**From:** Tom Errico <thomas.errico@tylin.com>  
**To:** "Donaldson, Helen" <HCD@portlandmaine.gov>  
**CC:** David Margolis-Pineo <DMP@portlandmaine.gov>, Katherine Earley <KAS@portlandmaine.gov>, Jeff Tarling <JST@portlandmaine.gov>, Jeremiah Bartlett <JBartlett@portlandmaine.gov>  
**Date:** 9/5/2012 2:07 PM  
**Subject:** Canal Plaza Hotel

Nell - The following summarizes my preliminary comments following a review of the site plan and traffic study for the project.

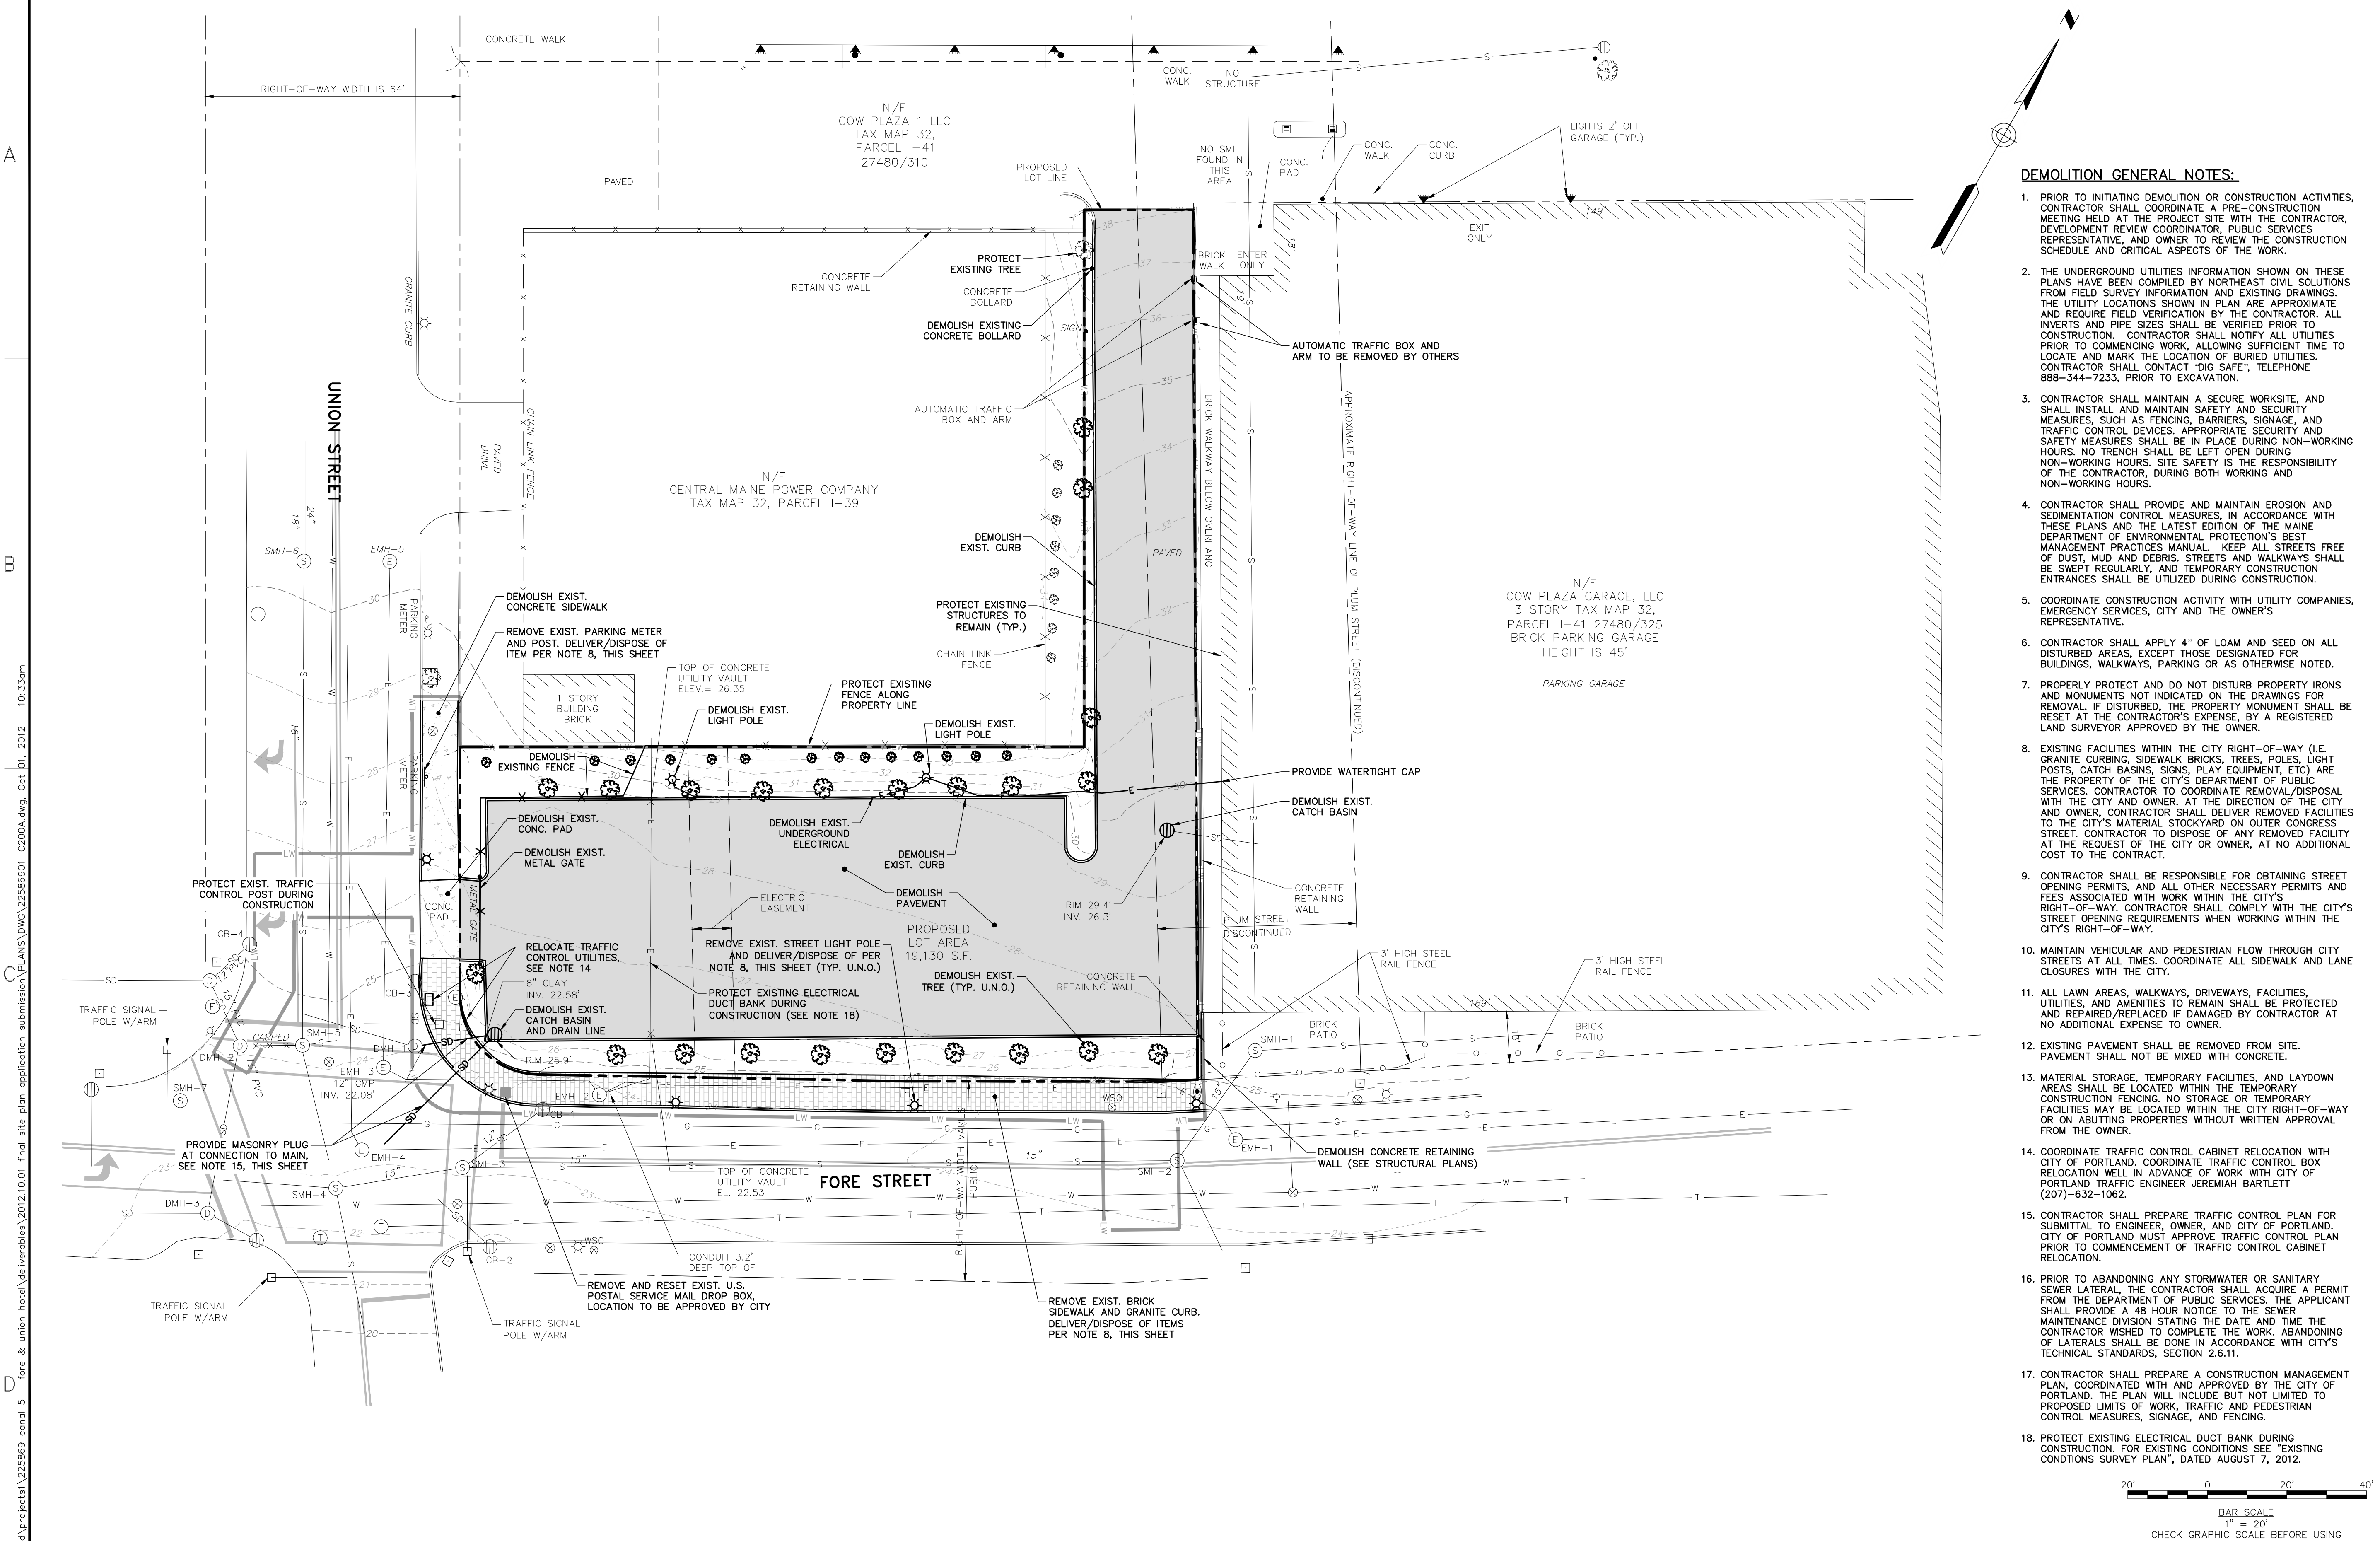
\* It is my suggestion that left-turn movements entering the hotel on Fore Street be prohibited due to long vehicle queues on Fore Street (from the Union Street traffic signal). In my professional opinion signage alone will not be sufficient treatment for enforcing this prohibition. The applicant should investigate geometric alignment changes for the driveway and possible treatments on Fore Street for restricting left-turn entry movements.

\* The applicant should conduct an analysis as to whether the radius on the corner of the Union Street/Fore Street intersection abutting the project site can be reduced in size. The City is interested in reducing the radius such that improved pedestrian accommodations can be incorporated including provision of preferred sidewalk ramp alignment. I would note that the City would be open to minor vehicle encroachment, if necessary.

\* The applicant should consider pavement treatment methods for differentiating the sidewalk pedestrian path crossing each driveway. This will help to ensure that vehicles queuing in the drop-off area will not block the sidewalk during busy time periods.

\* Given the location of the entry to the Hotel, I am concerned that there will be the tendency for guests to park directly next to the door, thus contributing to back-ups onto Fore Street. The applicant should provide information on how drop-offs will be managed.

\* The angle of the pavement markings for the at-grade passenger loading zone should be reversed.

\* The applicant will be responsible for design and implementation of signal equipment modifications on the corner of the Union

Street/Fore Street intersection (in conjunction with changes on the corner). In addition, other signal improvements will be required to ensure the signal meets current standards and is upgraded such that it is functioning as efficiently as possible. I will define the recommendations in the future.

\* On-street metered parking spaces will be lost on Union Street. This change will require council action and the applicant will be responsible for providing all supporting information for the inclusion in the council submission.
